Application for a non-material amendment following a grant of planning permission.

| Property name                                                            | Land At Salt Box West Of |

Reference number: BE/135/18/PL

MountfordPigott
Architecture Masterplanning Design
DRIVE THRU 2
PROPOSED ELEVATIONS
1744-DT2-P03-C
1:50@A1/1:100@A3
DRAWN BY ACD
07.12.18

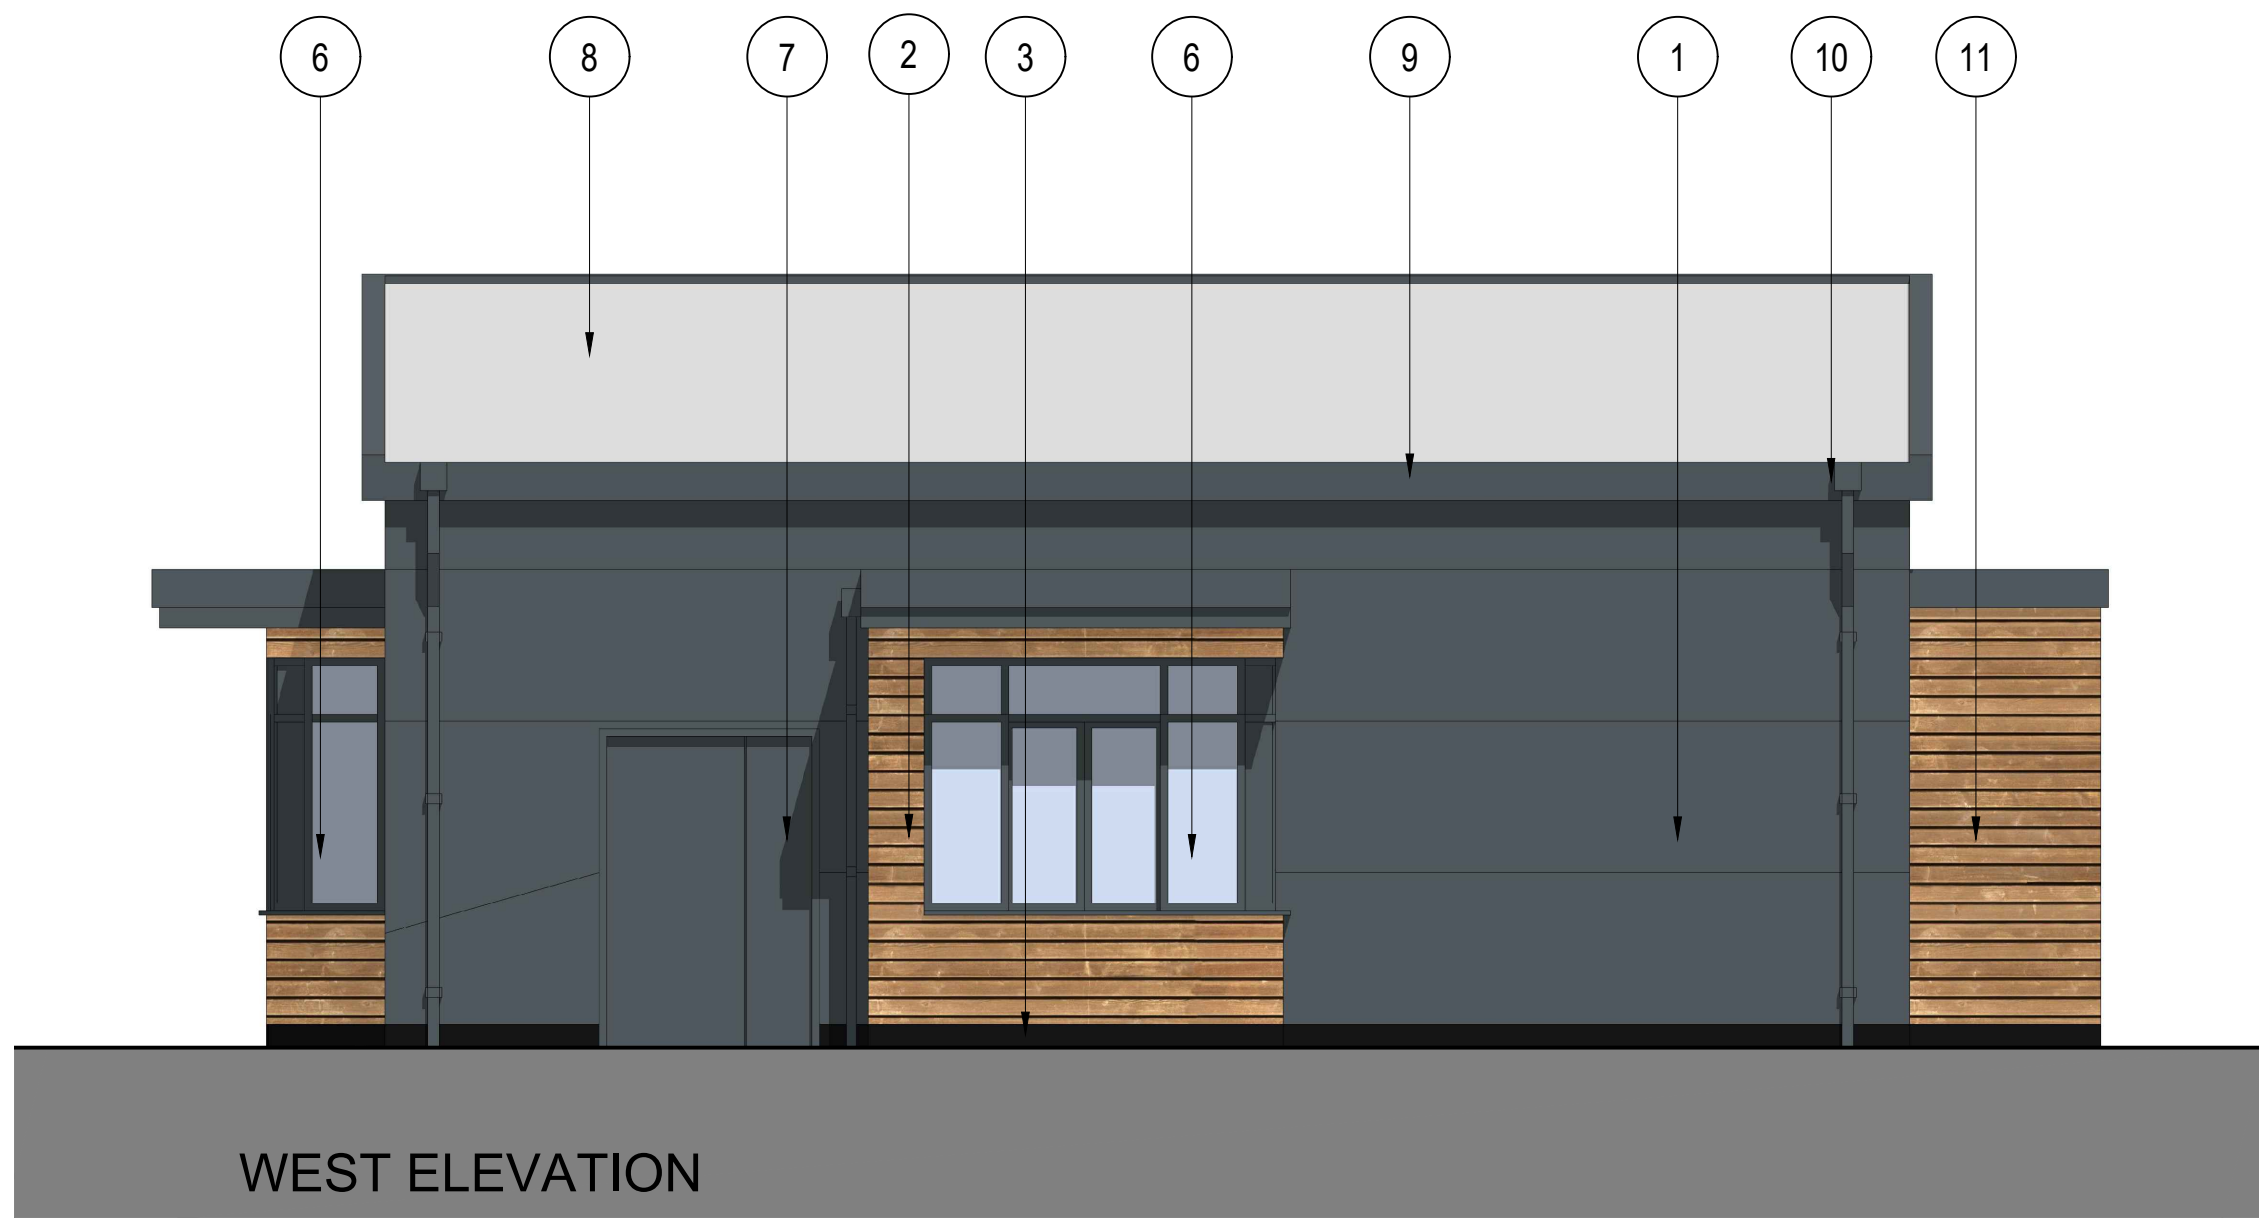
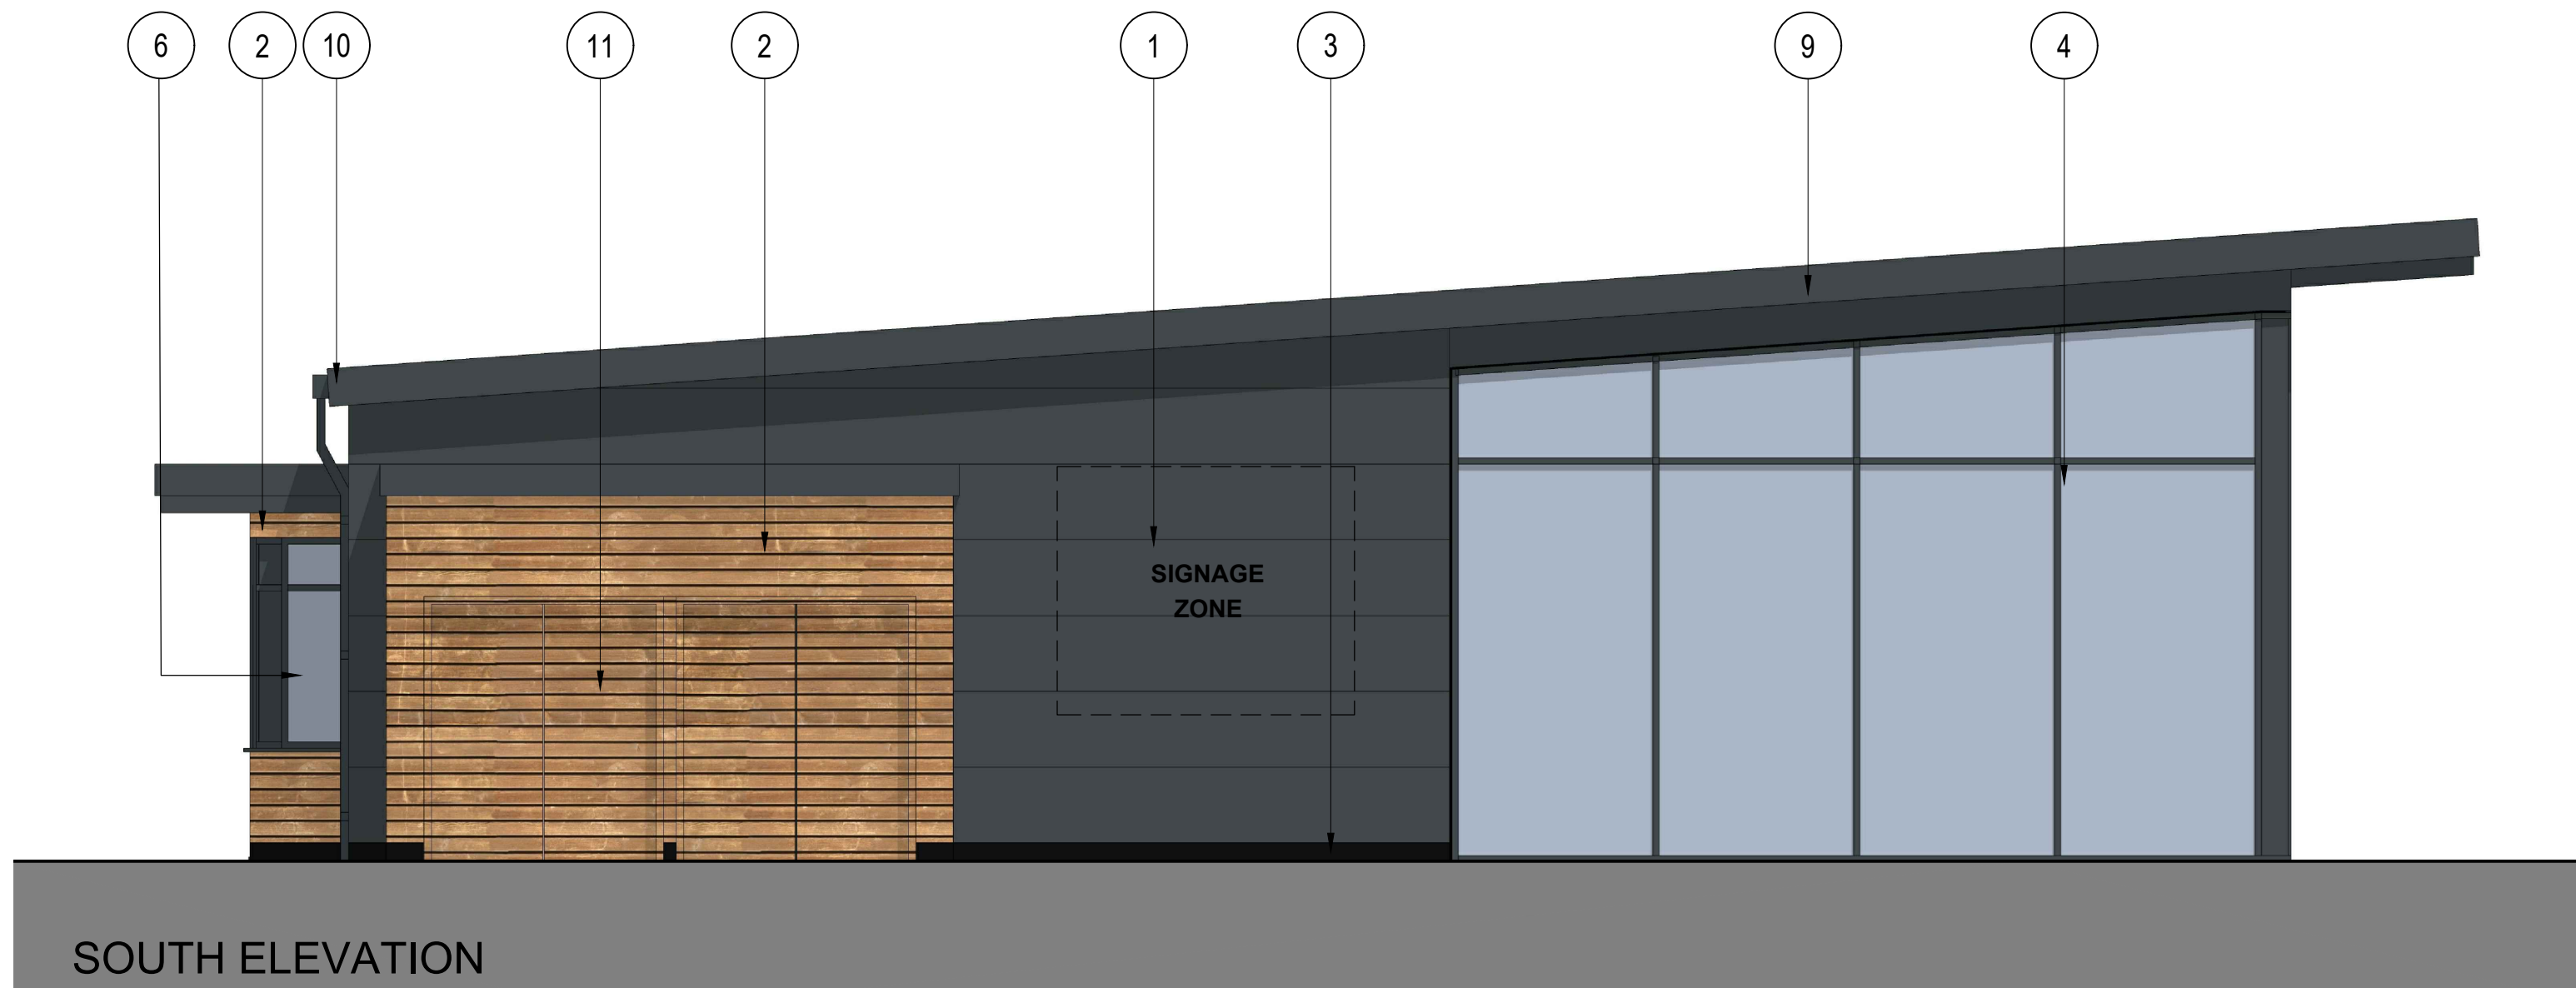
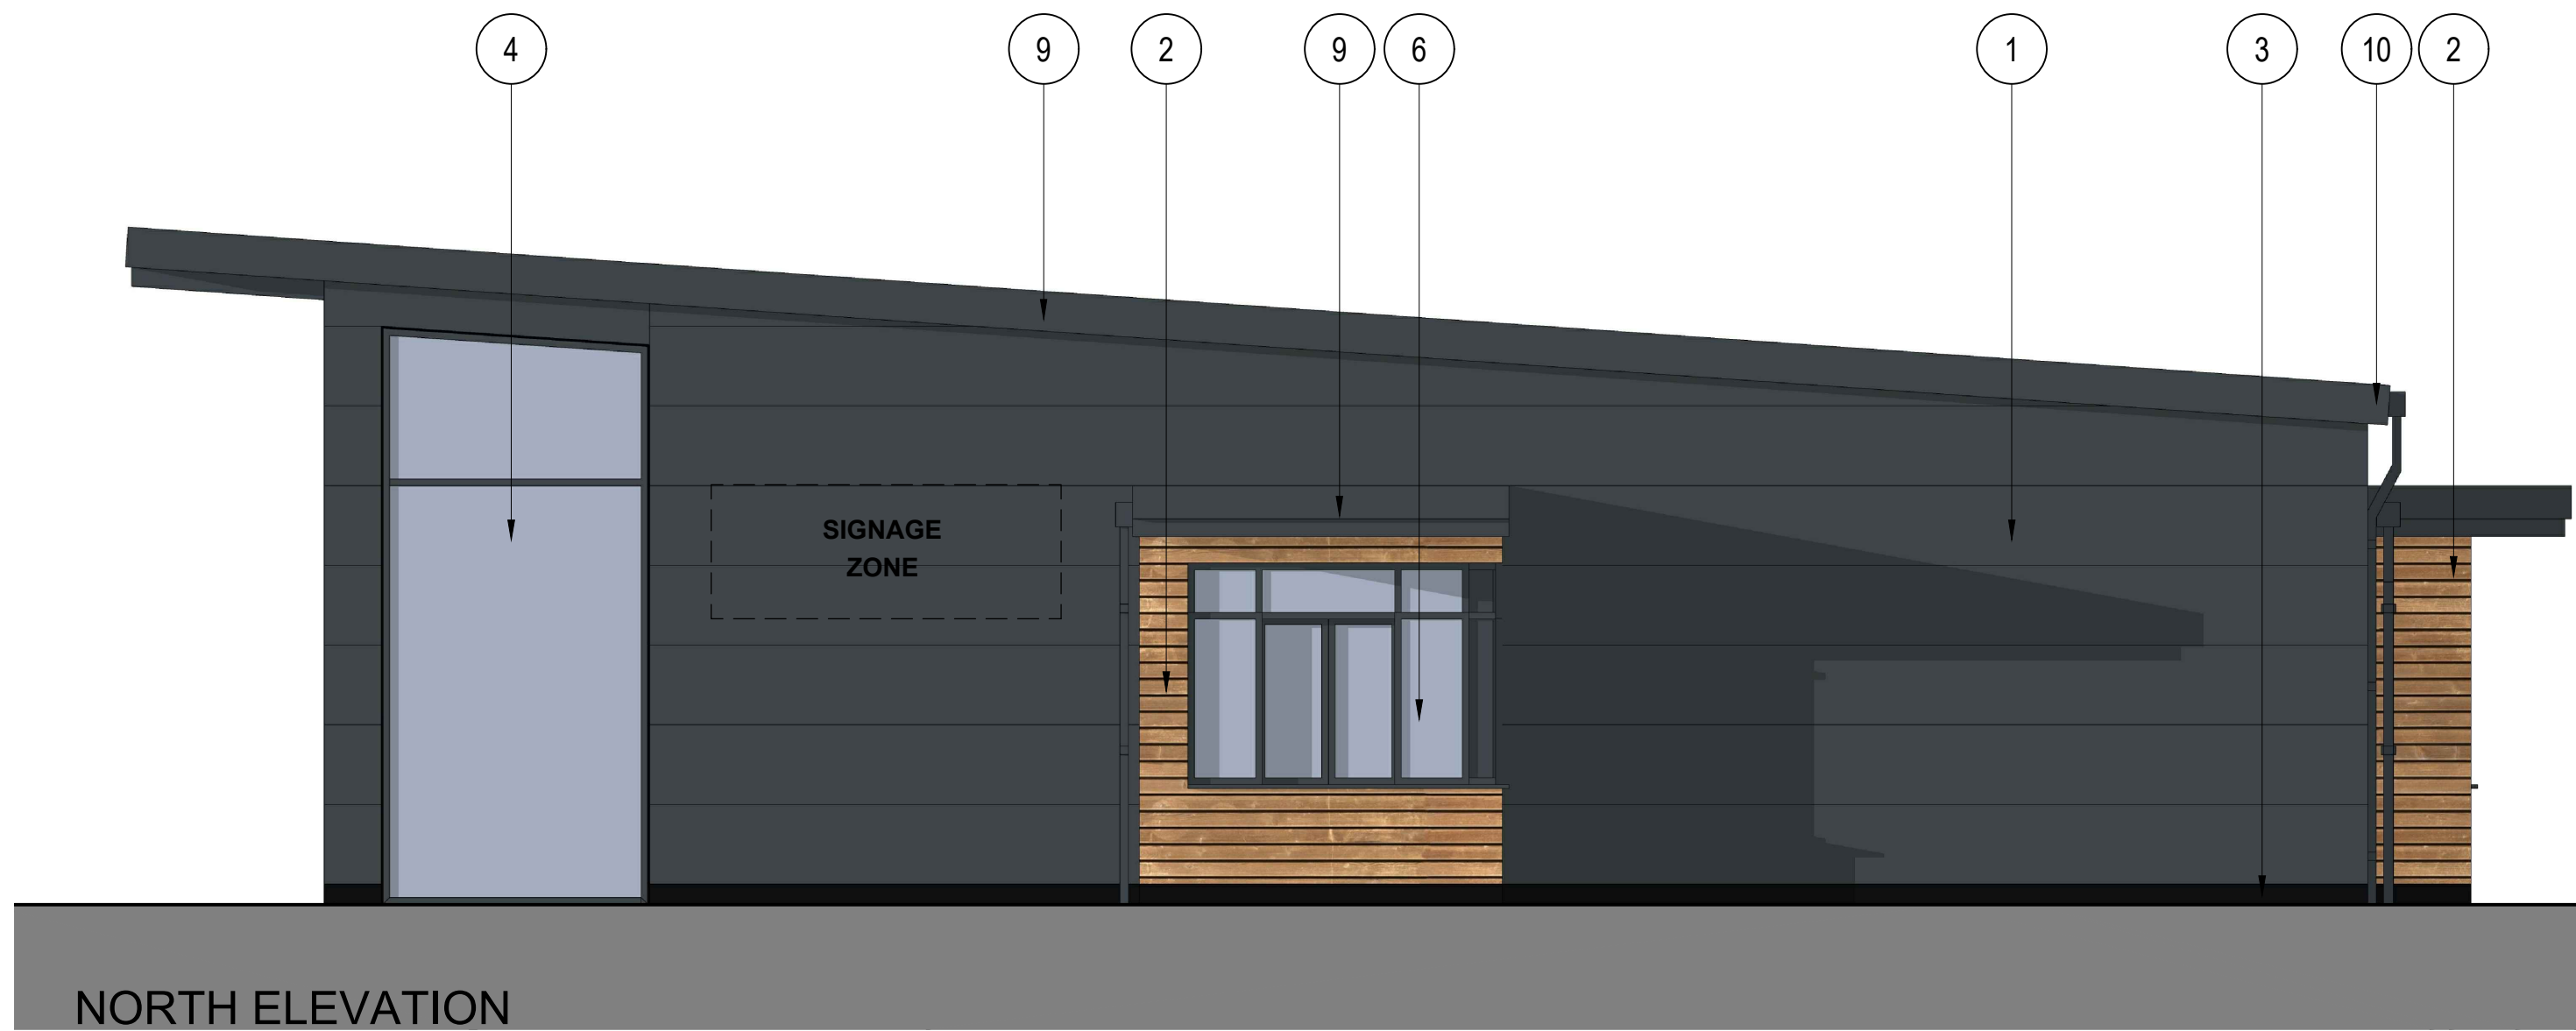
Unit 5 plans, elevations and sections updated to include: Canopies over drive-thru windows added, drive-thru windows revised, curtain walling mullions/transoms re-positioned, roof colour corrected, cantilevered beams added to roof overhang
